**WEST SUSSEX COUNTY COUNCIL
HIGHWAYS AND TRANSPORT SERVICES CONSULTATION**

SUBJECT: Y/65/07 - Proposed erection of 2 semi-detached houses

Land adjacent to, 60, Tack Lee Road, Yapton, West Sussex

[06-100-PL-01]

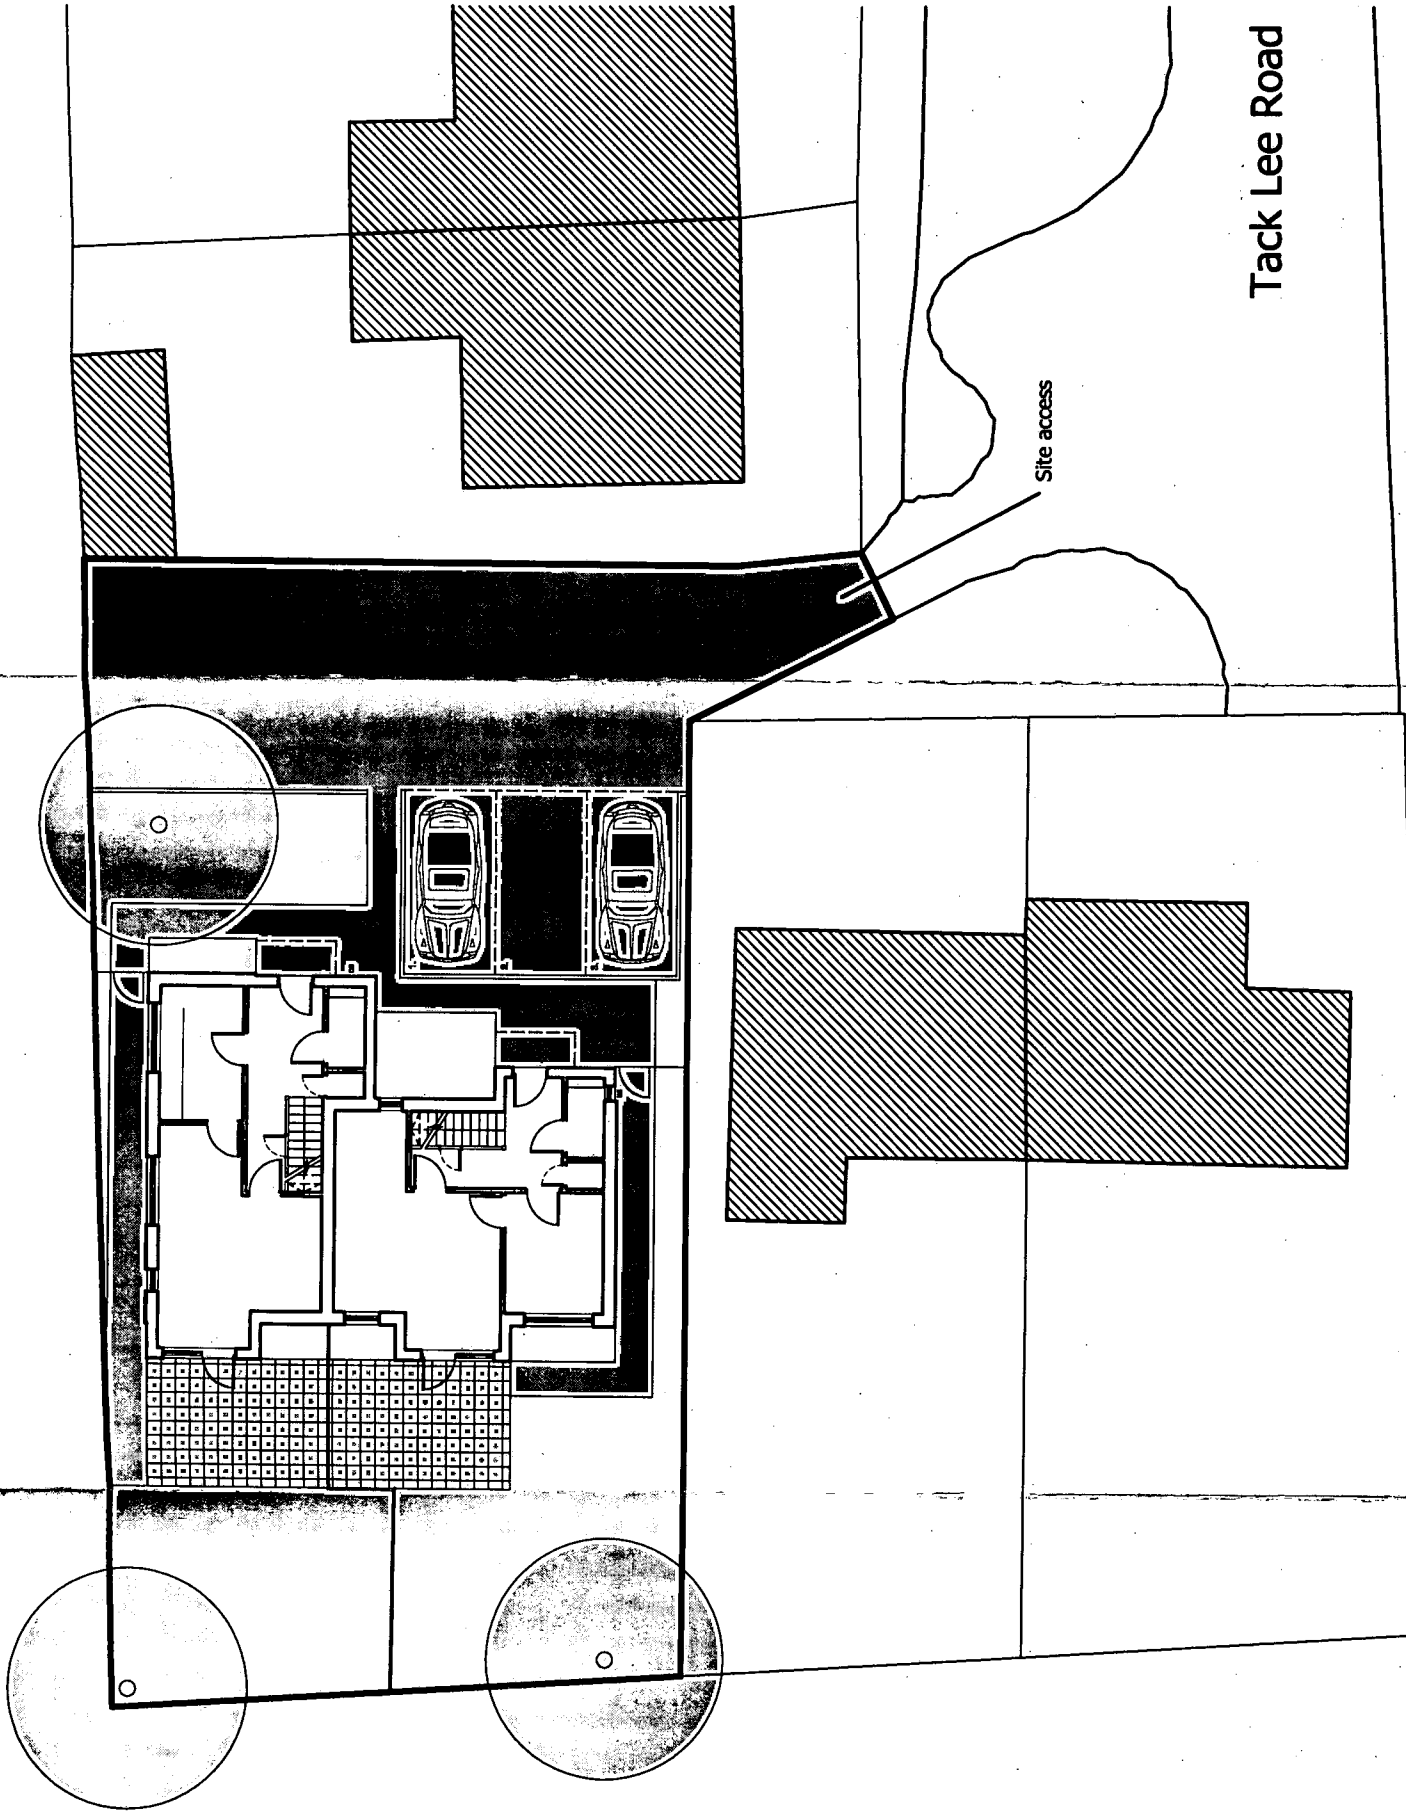
The site has an existing access off of the turning head at the far end of Tack Lee Road. No concerns would be raised in respects of the continued use of this. Three formal car parking spaces are indicated, although it is also noted that additional car parking could and most likely would take place in the turning area within the site. This shouldn't though pose any great issues as adequate space still exists to manoeuvre out of the formal bays.

No highway objection would be raised.

Parking and turning areas to be provided prior to occupation.
